CITY OF PORTLAND

BUILDING PERMIT

Job ID: 2011-11-2790-DRG

has permission to 32' x 28' Detached Garage w/ a Second Floor Exercise Room.

NORTH ELEVATION  
(FACING HOUSE)

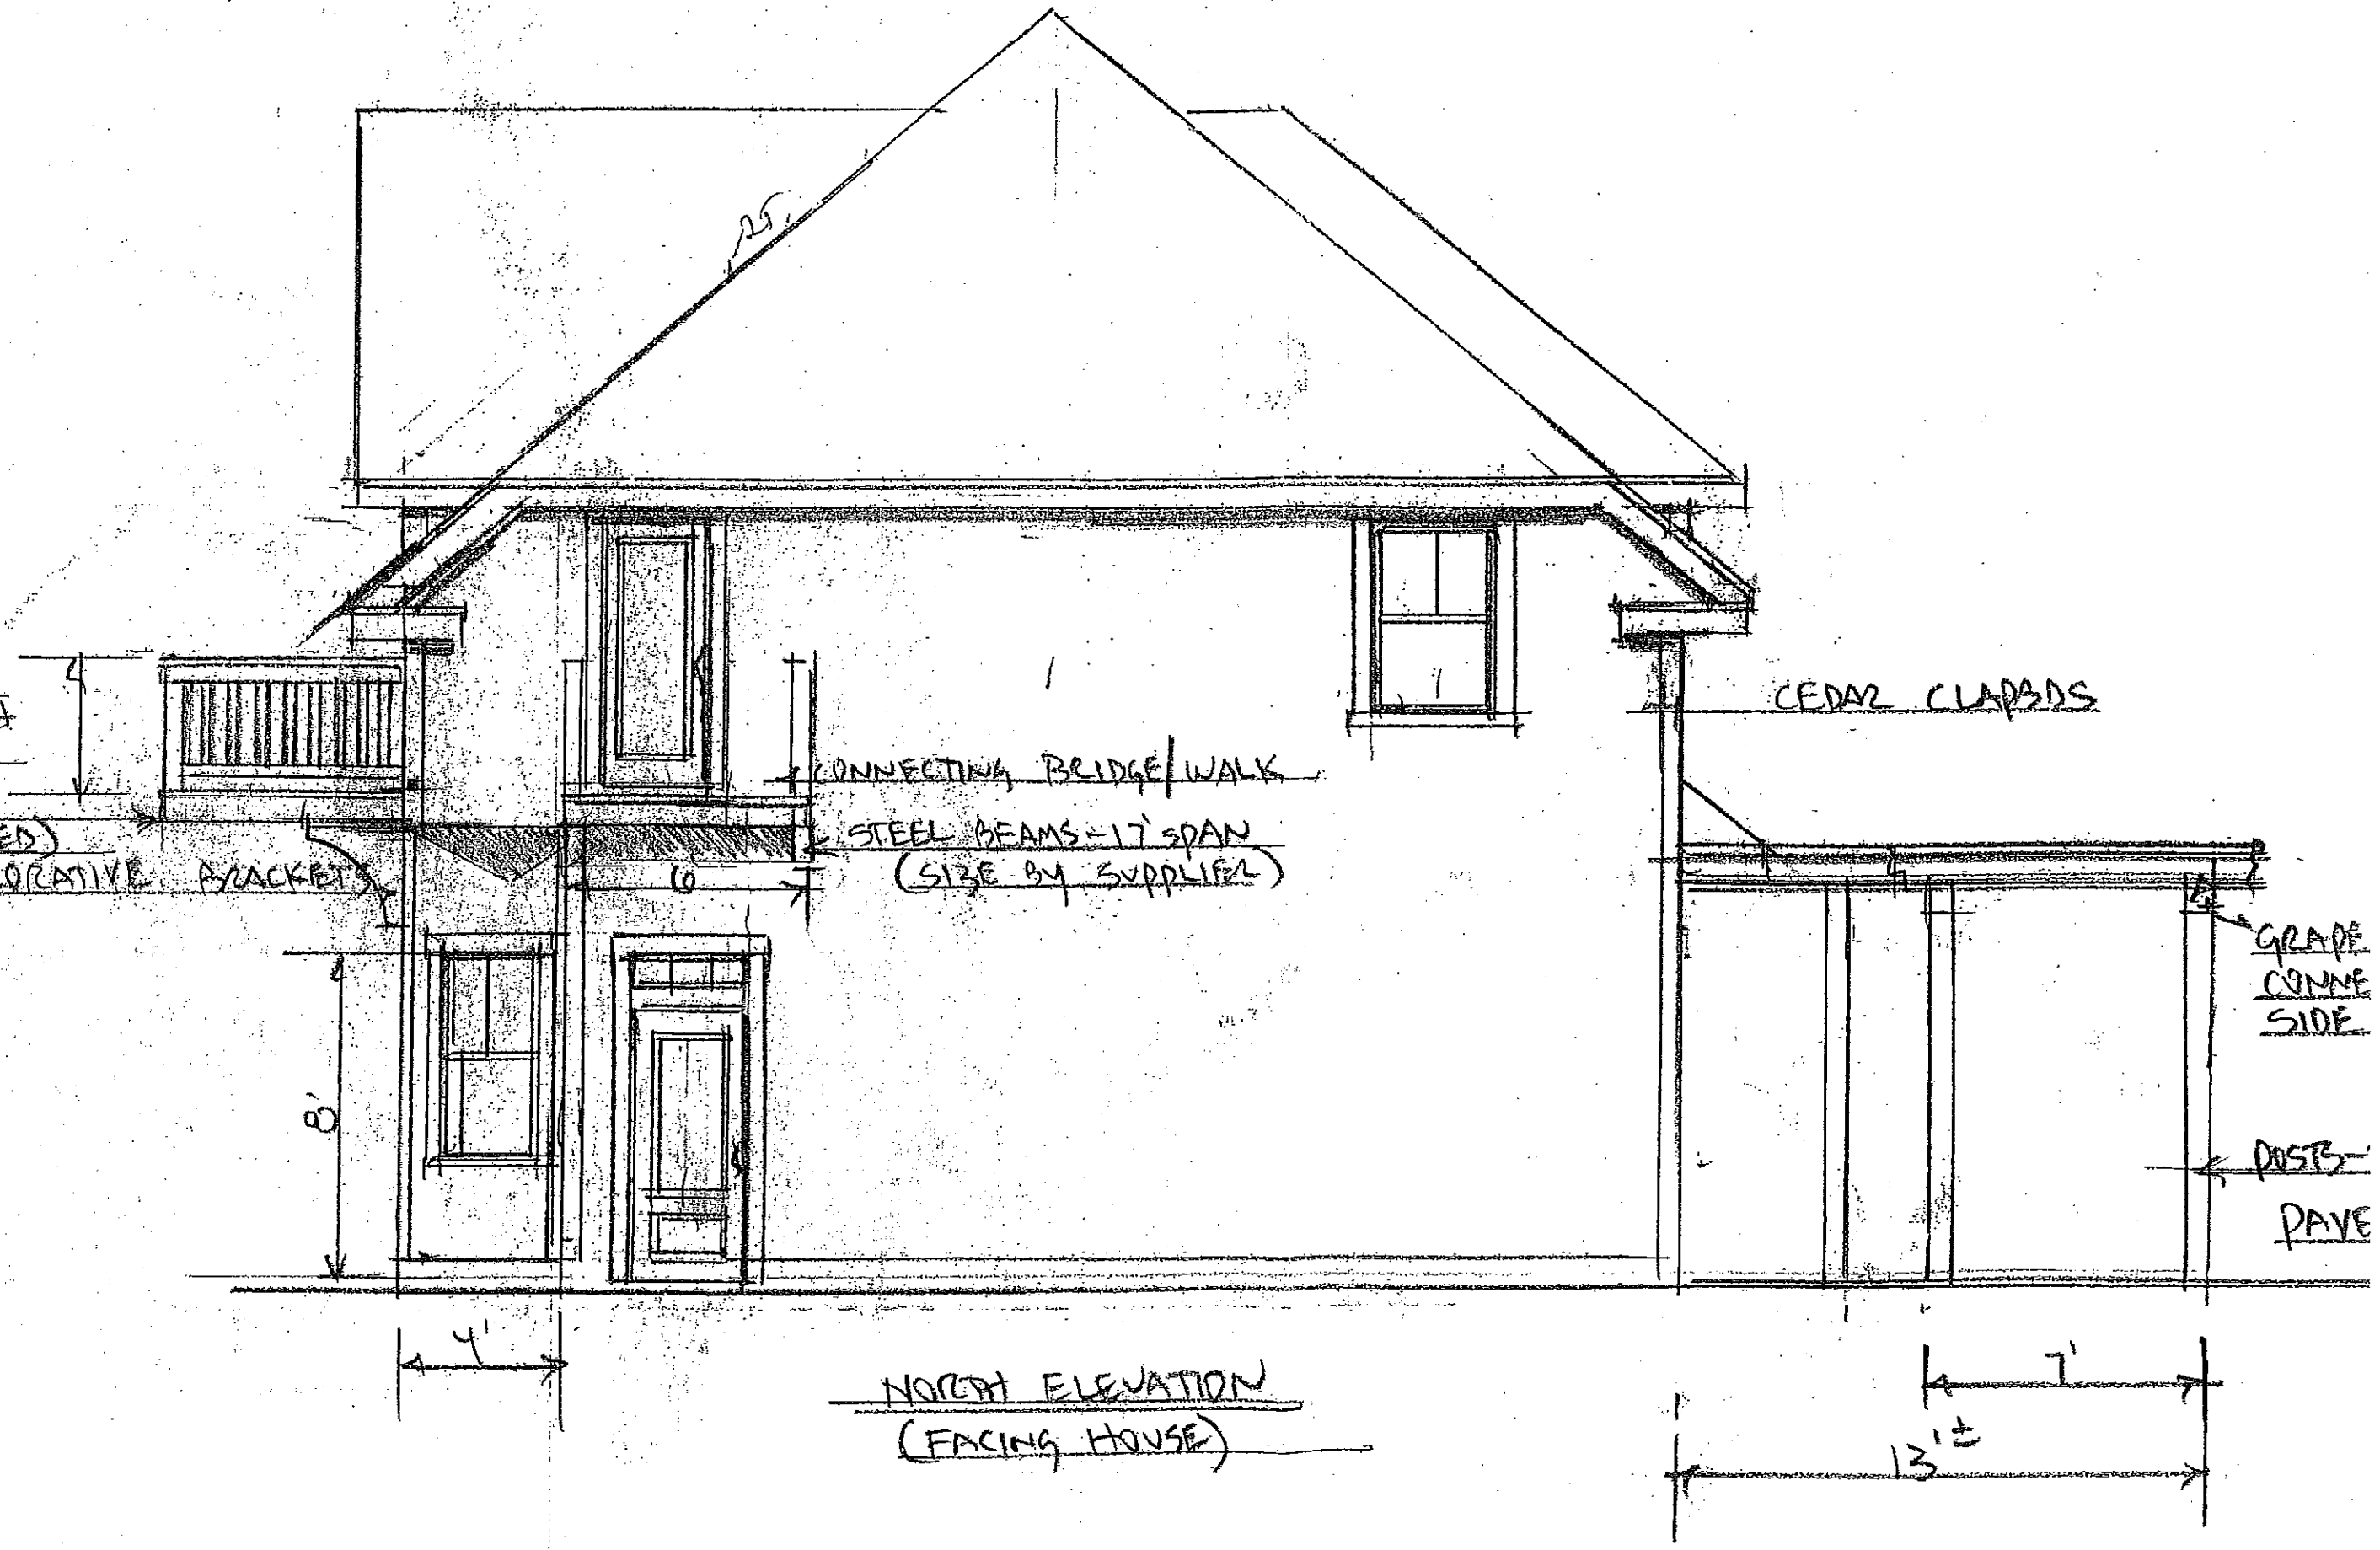
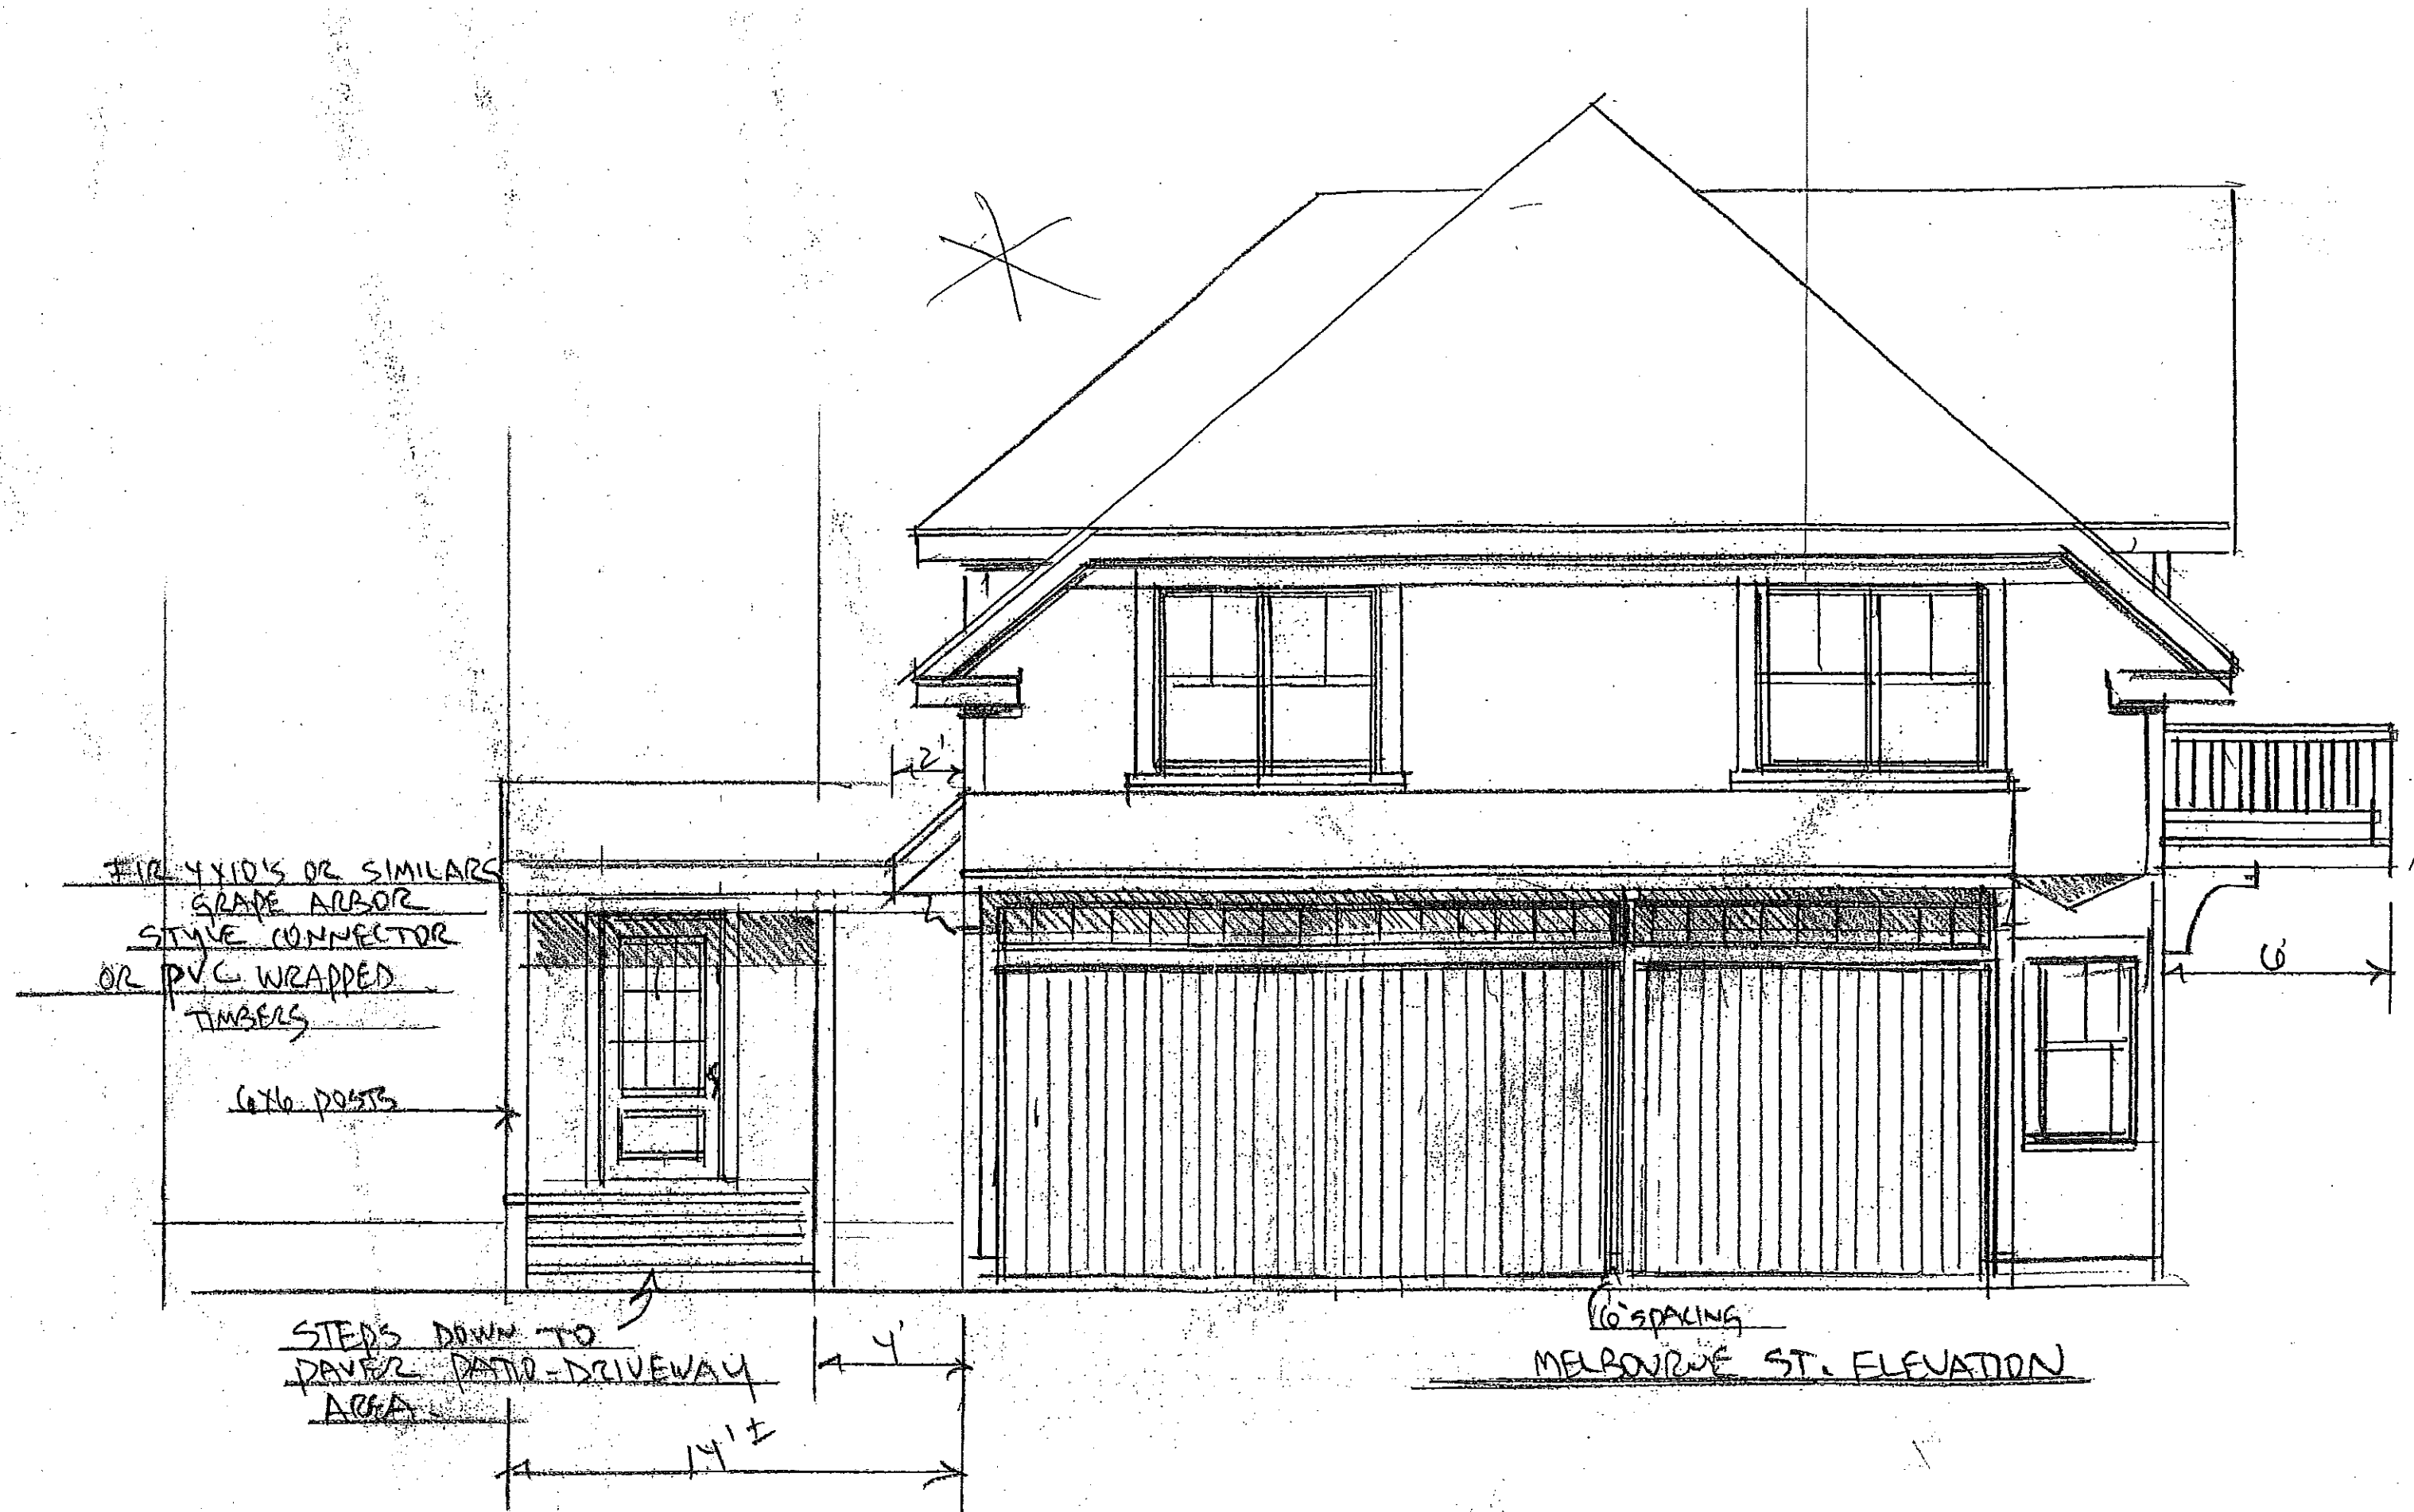
Height - ~~18'~~ 45' attached (principal) structure - scale @ 25.5' (OK)
for accessory detached structure - scale @ 24'

11-30-11 Permit is on hold. Spoke to owner. Told him that the maximum height allowed for a detached accessory structure is 18'. He will get back to me. He may attach it with a covered breezeway. -amachado

12-5-11 Owner submitted revised plans attaching the garage to the house by a 6' x 17' roof with a deck on it. The revised plans also changed the size of the garage to 32' x 28'. -amachado
